Ecology response

From: Jonathan Best <Jonathan.Best@arun.gov.uk>
Sent: 11 December 2024 16:45
To: Planning.Responses <Planning.Responses@arun.gov.uk>
Cc: Simon Davis <Simon.Davis@arun.gov.uk>
Subject: P/114/24/RES

Land west of Pagham Road Pagham.

I have reviewed the reserved matters applications above holistically, and with regards to ecology and Biodiversity Net Gain.

ATTENUATION BASIN 1 DETAIL

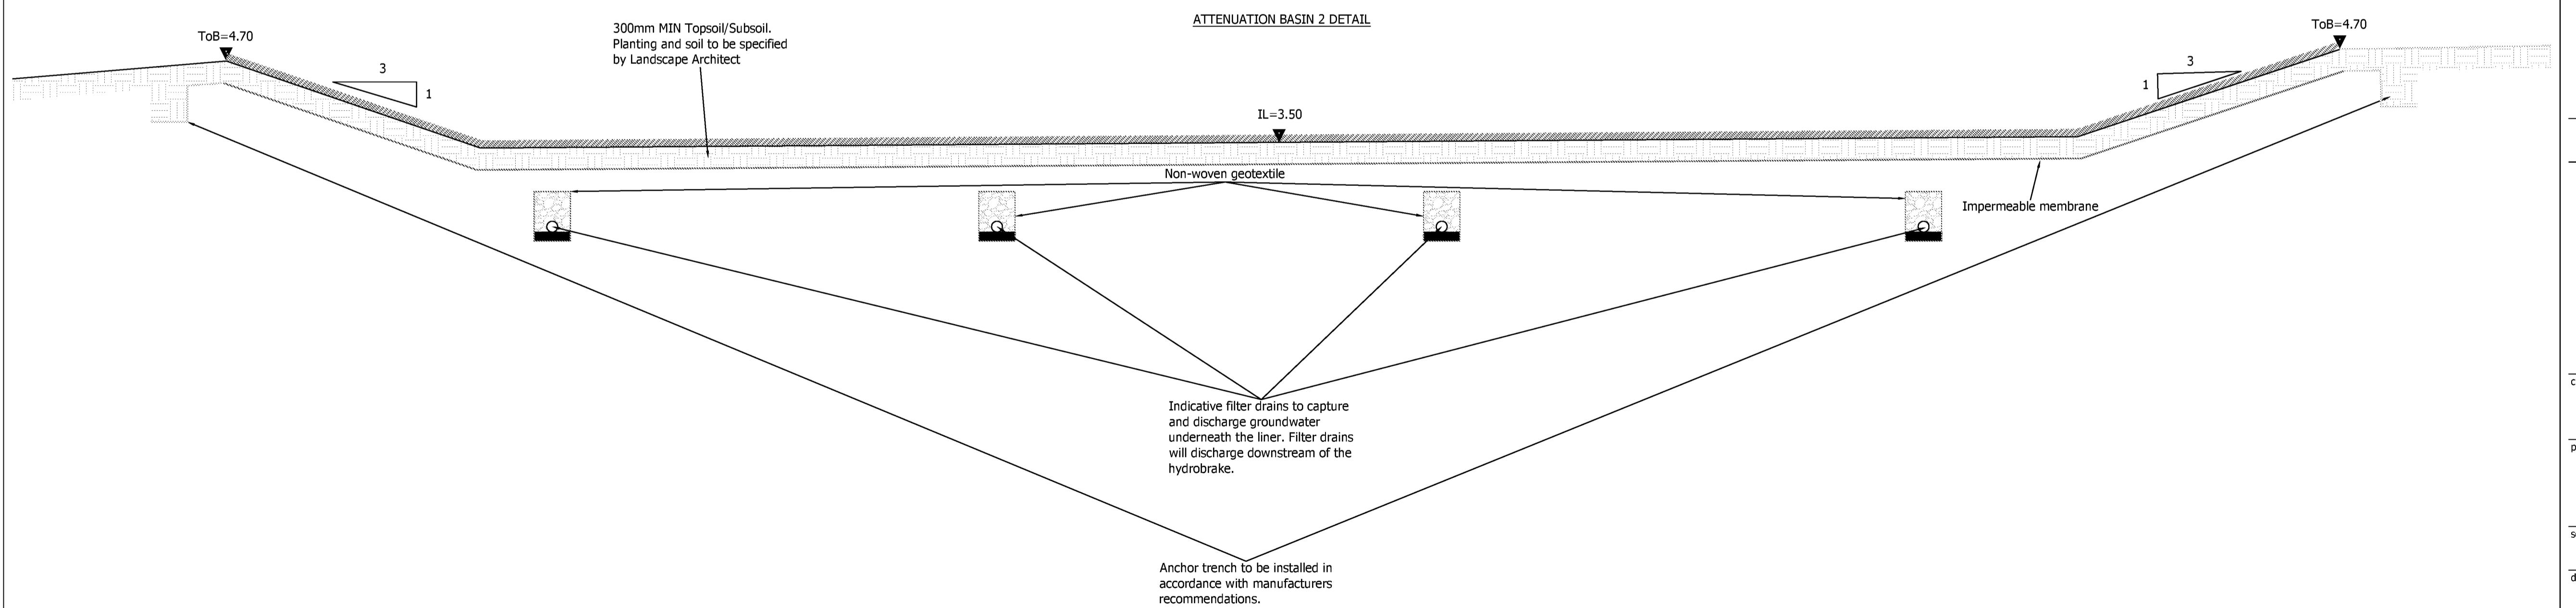
Guidance from the Freshwater Habitats Trust suggests that the ideal side of a pond for wildlife is 1:5 where the drainage information show a steeper 1:3 side.

Clarification of the pond's specification in relation to the sides and depths is required.
